Drafted 13 November 2012

**Planning Application, Ribble Valley District  
3/12/0839 Stanley House, Lowergate, Clitheroe**

Public Realm, Ribble Valley  
LCC Environmental Services East  
01254 828060

1:200 TH

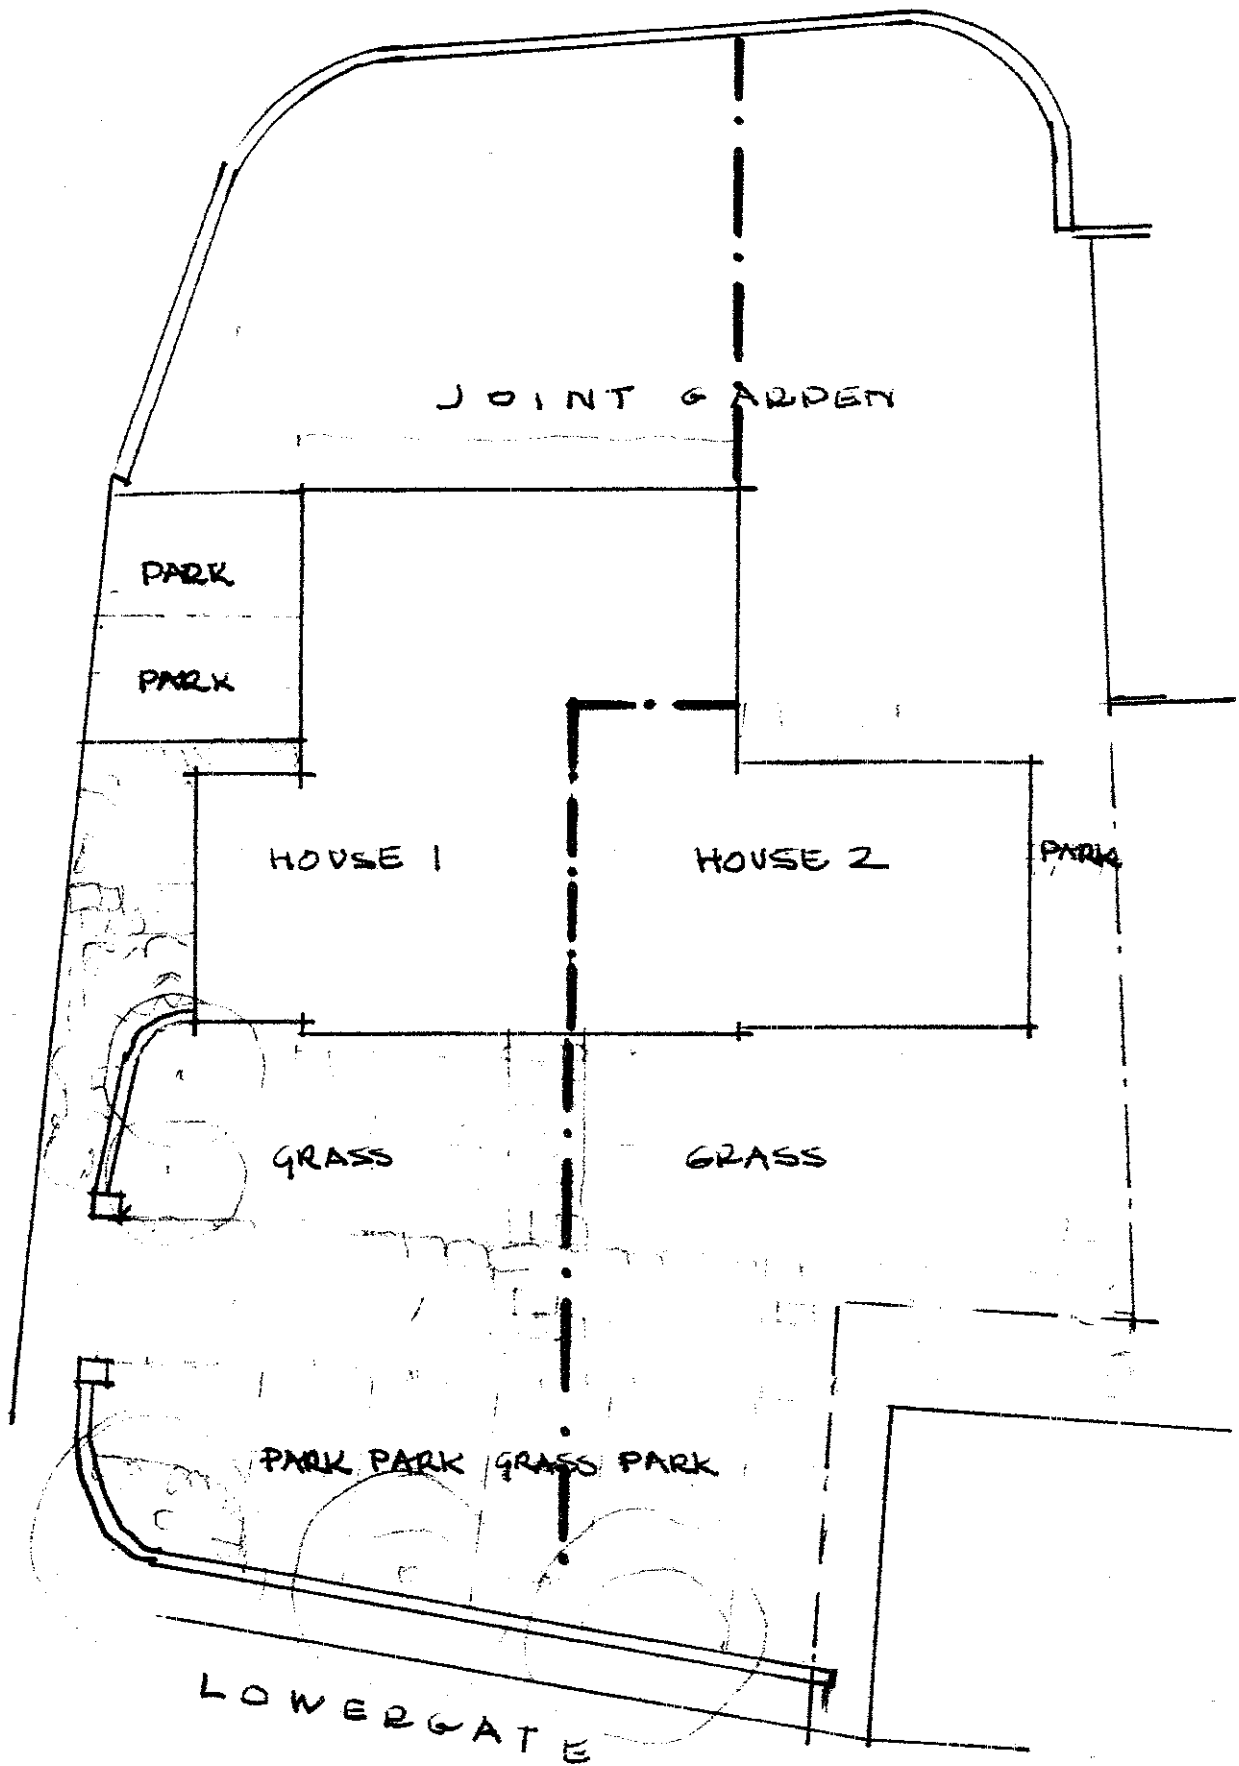
However, the parking layout shown on the site plan is not satisfactory as it does not secure a suitable parking arrangement for six vehicles, with appropriate manoeuvring to ensure that ingress and egress to the site can be achieved in a forward gear.

I have no doubt that the necessary parking arrangements can be achieved from within the available residential curtilage. Therefore, I would welcome either the submission of an amended site plan prior to a decision being made on this application or, should your Planning and Development Committee be minded to give consent to this application, a suitably worded Condition stipulating that a parking layout would have to be agreed by both the Local Planning Authority and the Highway Authority prior to work commencing on site.
